Project # 1003127

Project Name: EAGLE RANCH SUBDIVISION

**CITY OF ALBUQUERQUE
PLANNING DEPARTMENT
Development Review Board
April 28, 2004
Comments**

Re: Vista Square/SPBP

DIRECTOR'S SIGN 1/4" = 1'-0"

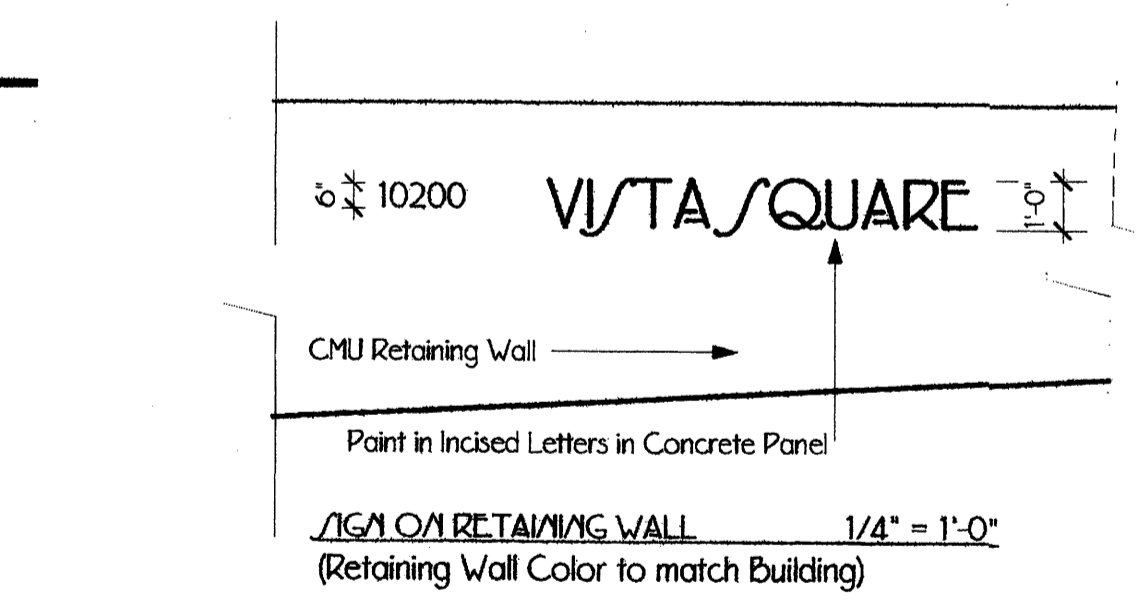
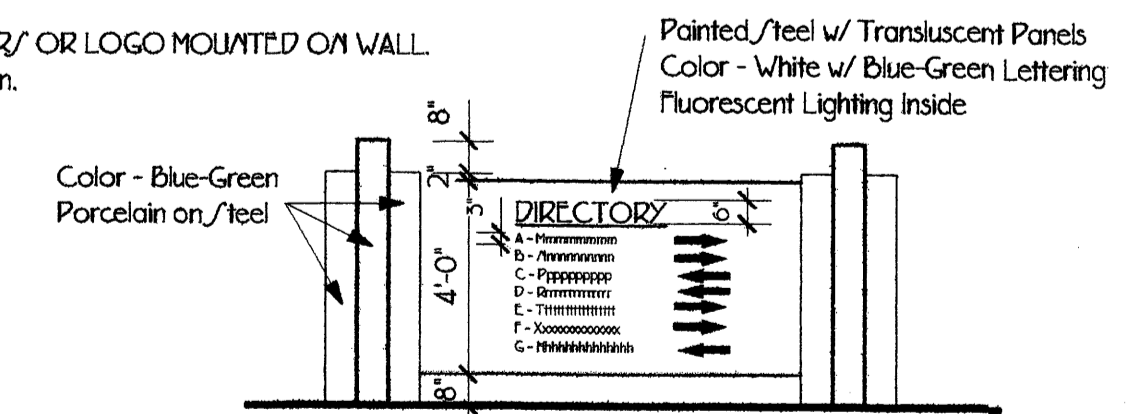
- o This sheet indicates a retaining wall with the words "Vista Square" on it. What is the minimum & maximum height of this wall? It is likely a perimeter wall design submittal is required to receive approval to build the wall during the wall moratorium. The Front Counter has the submittal requirements & Planning has the proposed Zone Code amendments to be met to receive a wall permit during the moratorium.
- ✓ The width dimension on the directory sign is missing on the elevation drawing.

✓ The SPS also states that one 50 foot monument sign for future pad sites will be permitted. The directory sign should meet this requirement.
